**Subject:** FW: Planning Feedback - Ref: 23/0610/OUT Church Farm Station Road Elmhursthorpe

**Subject:** Planning Feedback - Ref: 23/0610/OUT Church Farm Station Road Elmhursthorpe

BLOCK PLAN AS PROPOSED

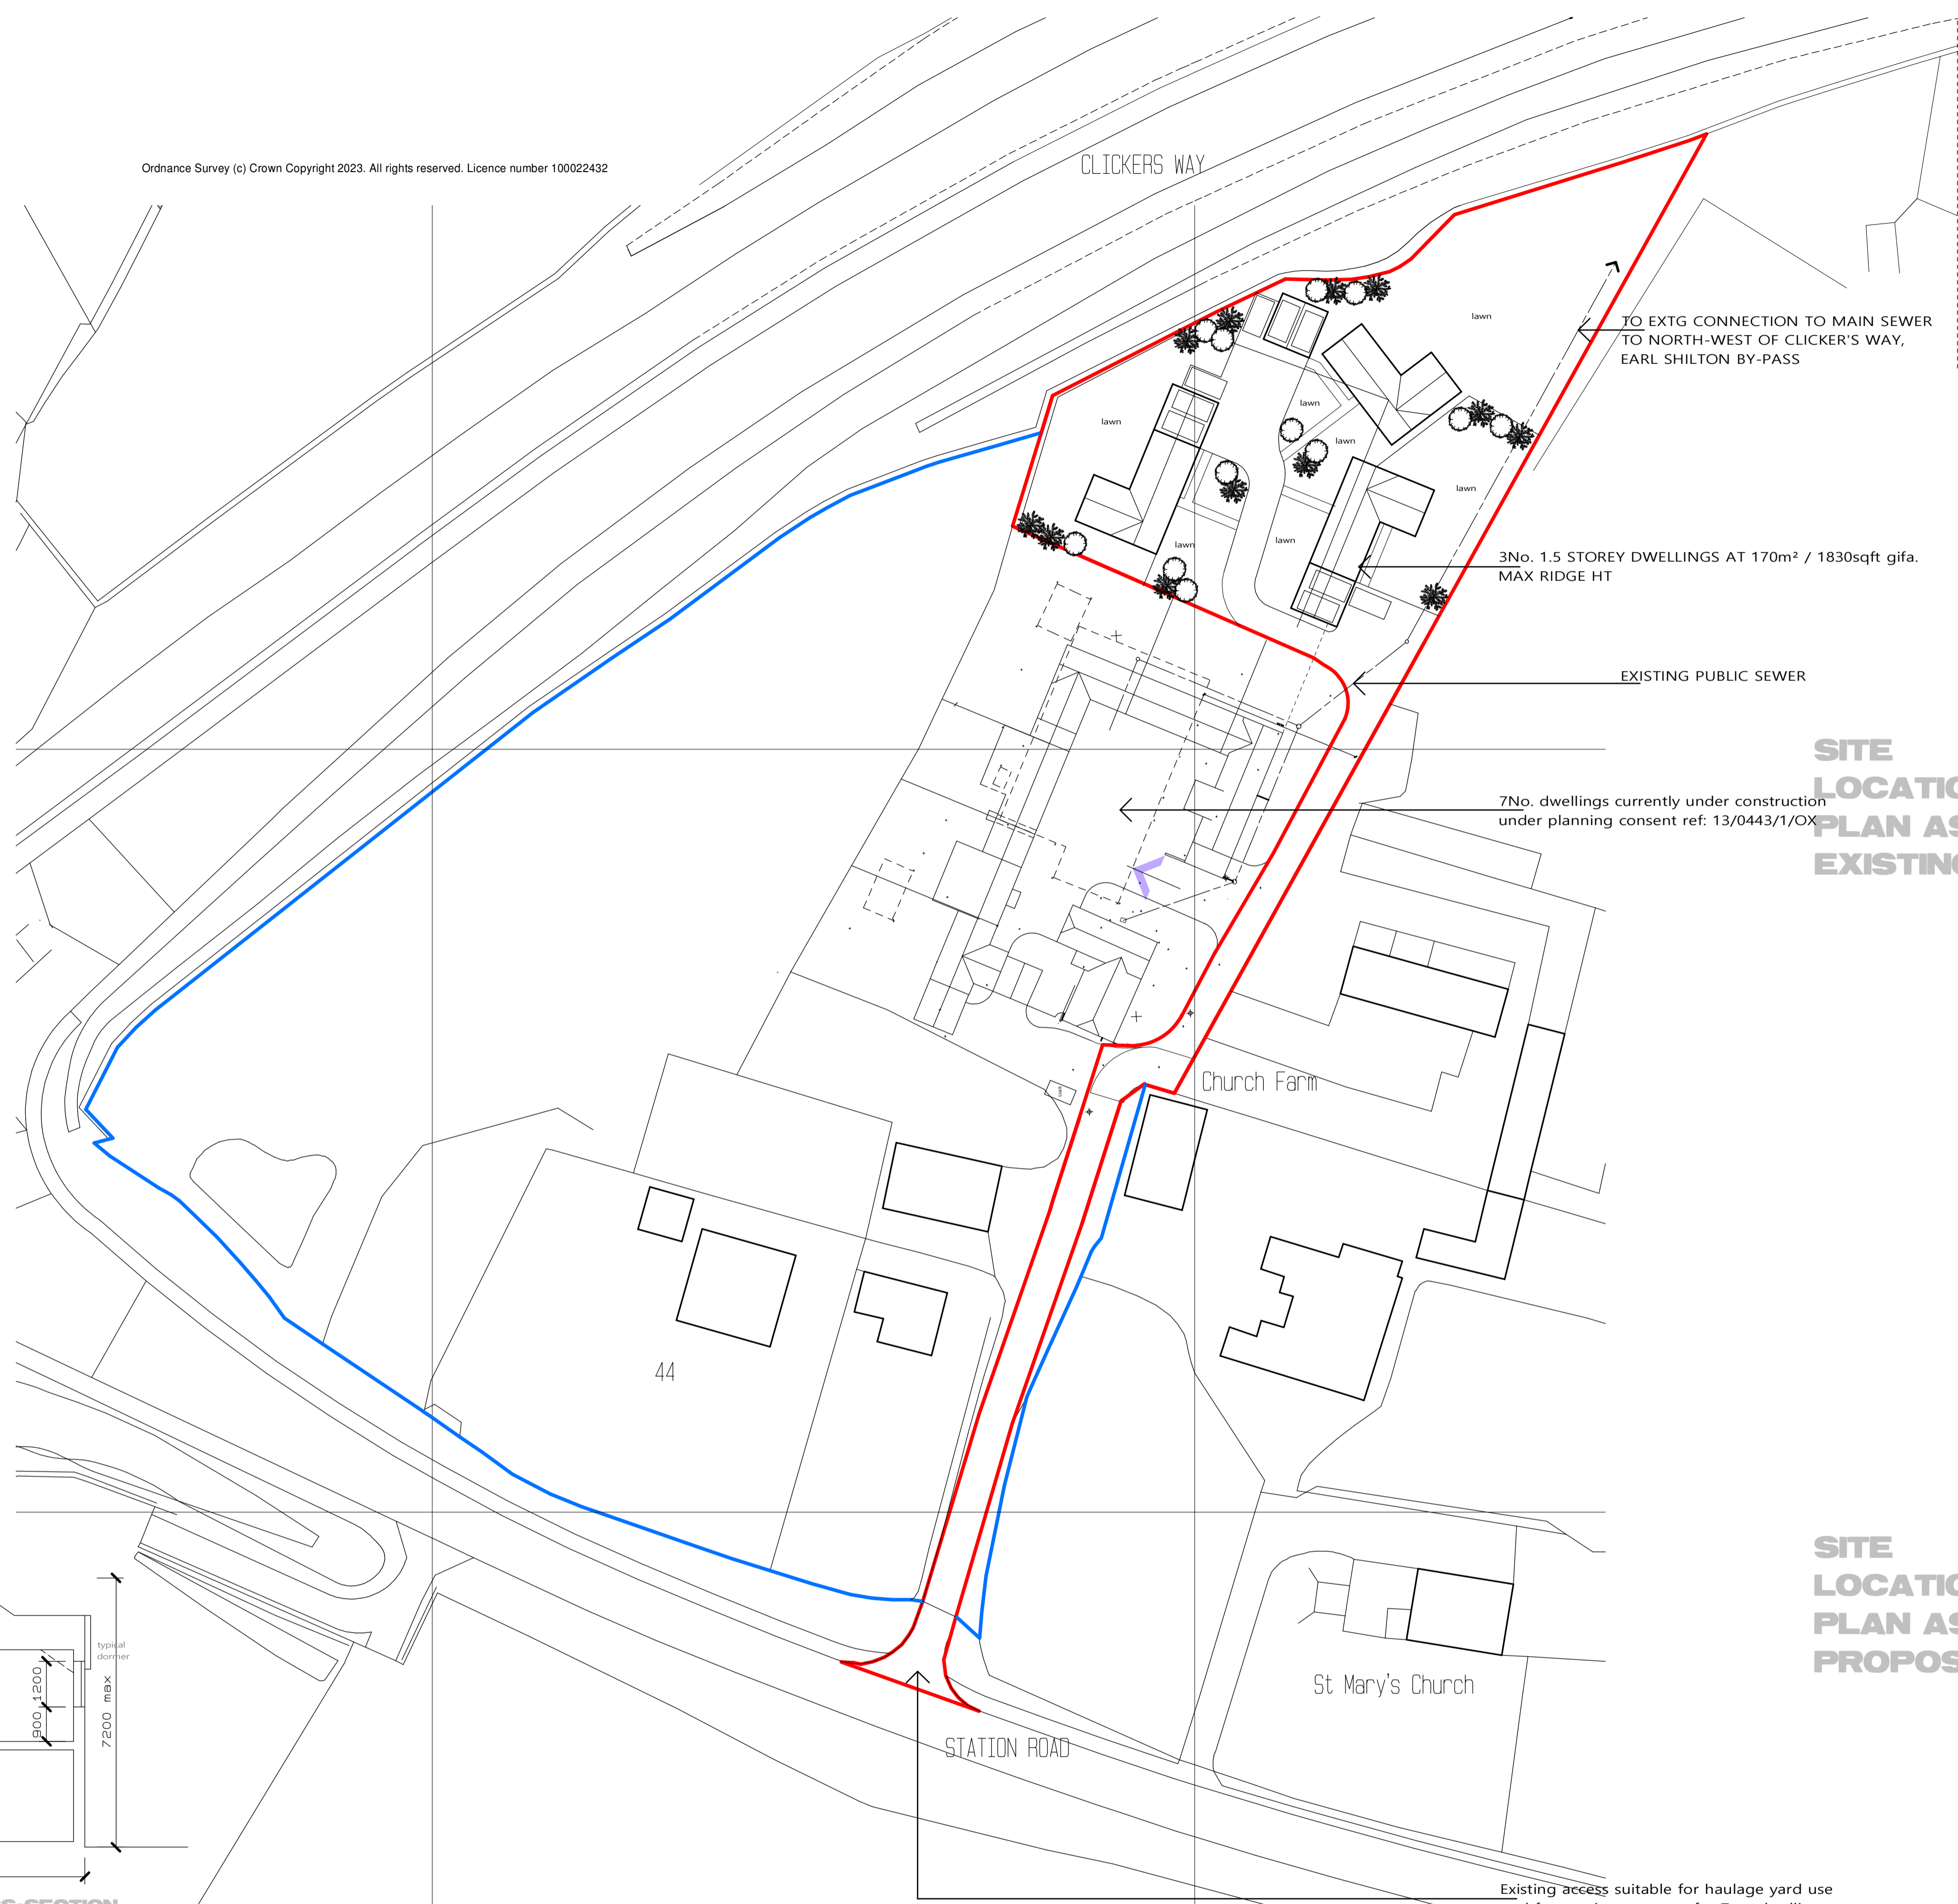
1. Please observe the contents of the guidance documents attached.
2. It is not clear where residents should present their waste containers for collection. Households are required to present bins for service at the boundary of the public highway. If the road serving the new properties will not be adopted as public highway then adequate bin collection points should be included in the plans and situated at the boundary of the public highway and be compliant with regulations (as detailed in the linked guidance documents) regarding reasonable distance from the bin storage point to the bin collection point.

At present we cannot see any dimensions for the access road or even the access road either so cannot accept this at present.
